## BUILDING DEPARTMENT PERMIT

Permit Number: 041367

This is to certify that Butler Alburn E & Tammy J. Michael  
has permission to build 576 sq ft garage on site demolish garage  
AT 20 St George St 082 E013001

<b>Dept:</b> Building	<b>Status:</b> Approved with Conditions	<b>Reviewer:</b> Tammy Munson	<b>Approval Date:</b> 10/15/2004
<b>Note:</b>	<b>Ok to Issue:</b> <input checked="" type="checkbox"/>		
1) Frost protection will be provided per the enclosed detail as discussed w/owner.			
2) Anchor bolts must be a minimum 1/2" diameter and spaced a maximum of 6'-0" oc.

CROSS SECTION

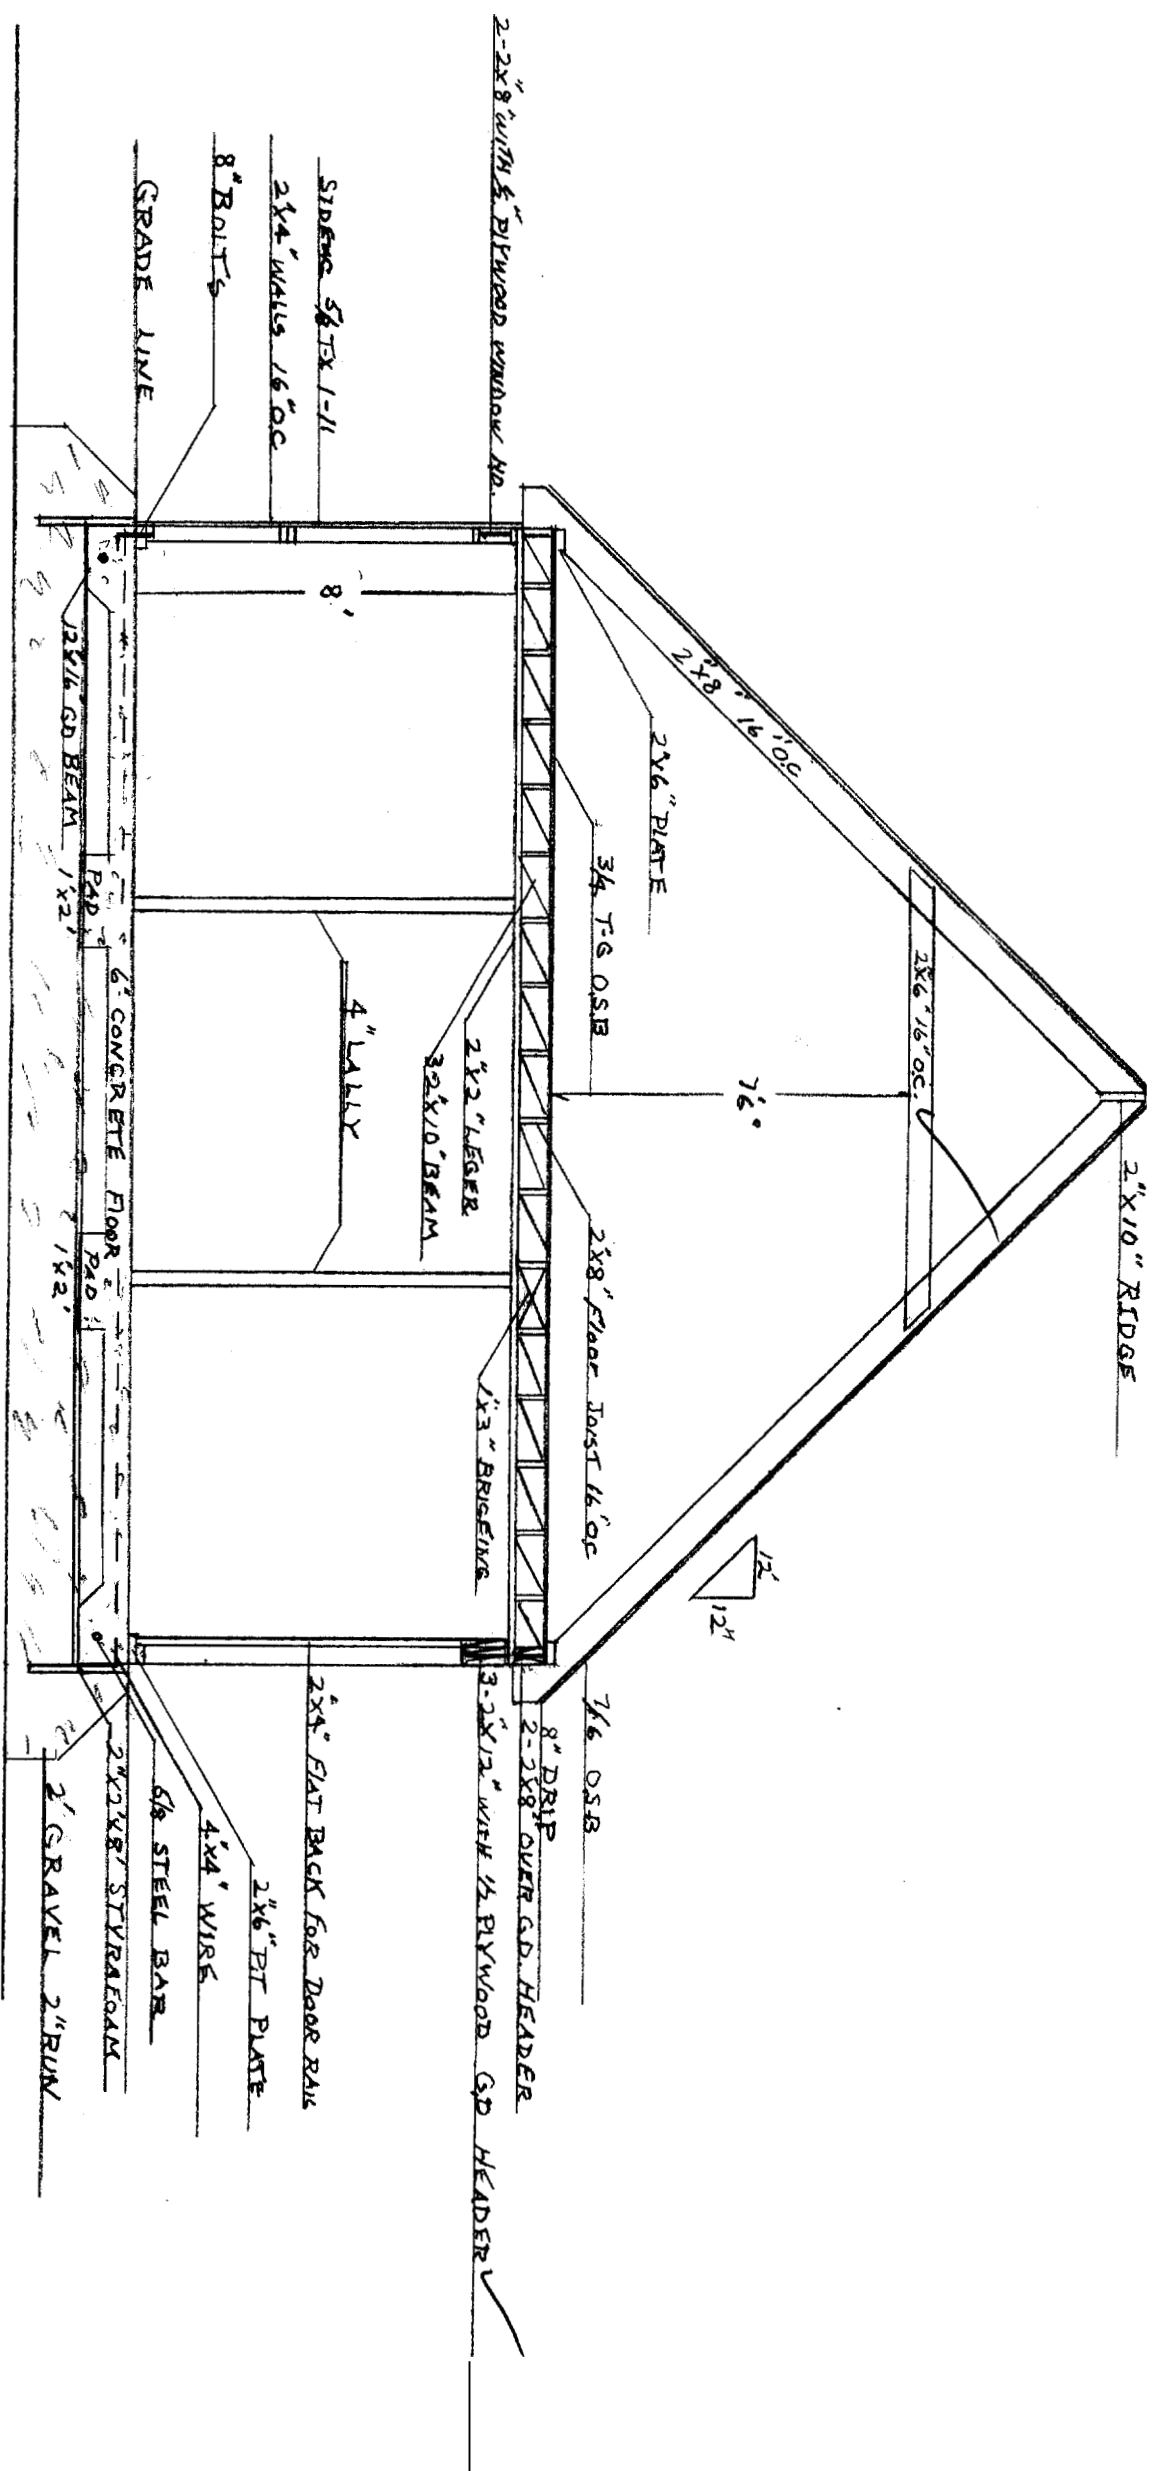
<b>Comments:</b> 9/29/04-tmm: left message for owner - need better plot plan 10/1/04-tmm: zoning ok- spoke w/owner - need stair details, guard rail info, header schedule, collar ties inadequate, frost protection of slab, and anchor vbolt info.
---
